CITY OF ALBUQUERQUE

**Re: Lot 2 Improvements, 6404 Acoma Road SE, Traffic Circulation Layout
No Stamp (K18-D97)**

Re: Lot 2 Improvements – SEC Acoma and Arizona
No Engineer's Stamp, (K18/D97)

GRADING AND DRAINAGE PLAN

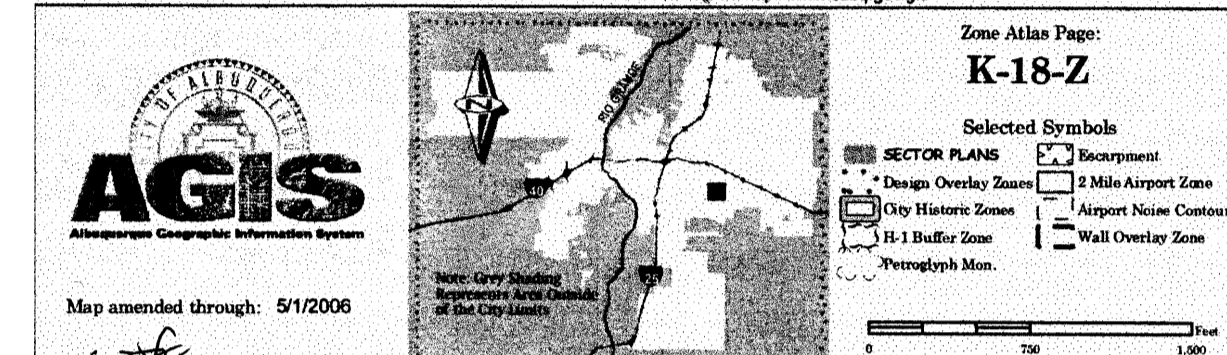
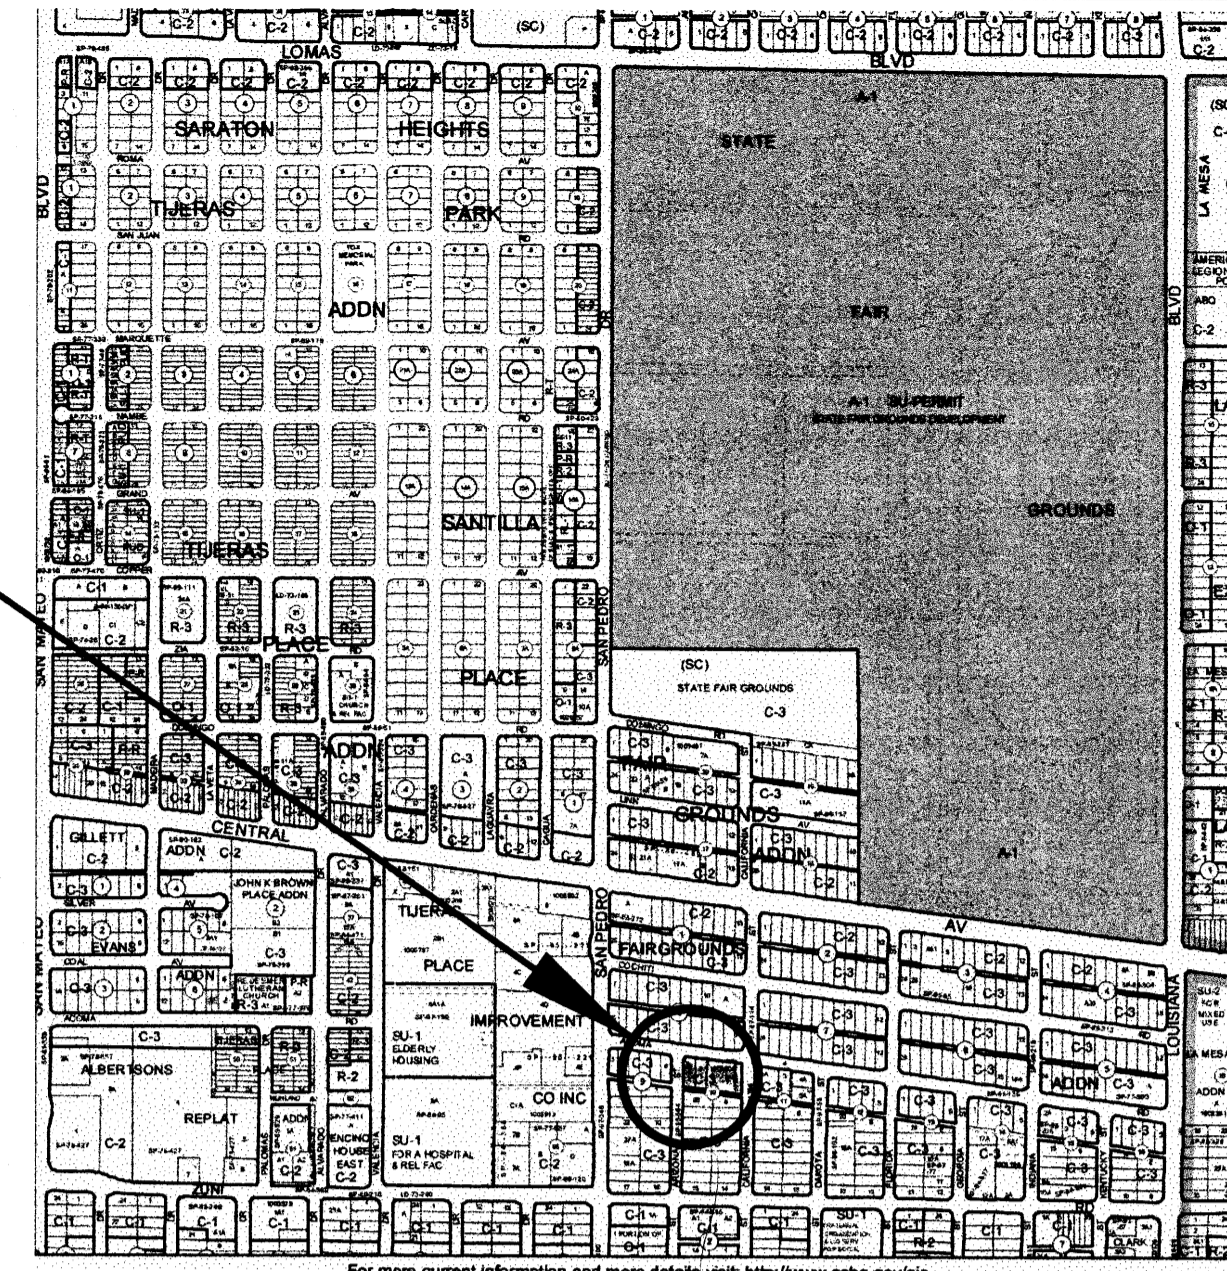
- Please provide an executed copy of a cross-lot drainage easement across lot 1 for the benefit of lot 2.
- Keyed note 3 references a 2' x 12' concrete apron at the south end of the site. However, the plan drawings show an 8' x 12' slab.

- Your runoff calculations appear to be in error. You indicate the impervious area will be approximately 1,917 square-feet (0.044 acres). The structure by itself is 1,800 square-feet. You show additional paving on the north and south sides of the proposed structure. Is the west side of lot 2 planned to be bare ground? What improvements will be made to lot 1 with this site work?

- Will additional curb be necessary around the western perimeter? How will flows be prevented from overtopping the sidewalk in Arizona? Please provide spot elevations within lot 1 so as to characterize the drainage patterns on that property given your developed condition.

- Your conclusions indicate that an SO-19 permit is desired. I see no sidewalk culverts or storm drain connections in this plan. Are additional connections desired? Please clarify.

- Is any off-site flow currently entering the site from lot 3A? If so, please quantify, discuss how that flow will be redirected, and provide spot elevations to indicate as much.

- Your spot elevations indicate that 6-inch curbs will be used on this project. As this is not a standard section, please provide a detail.
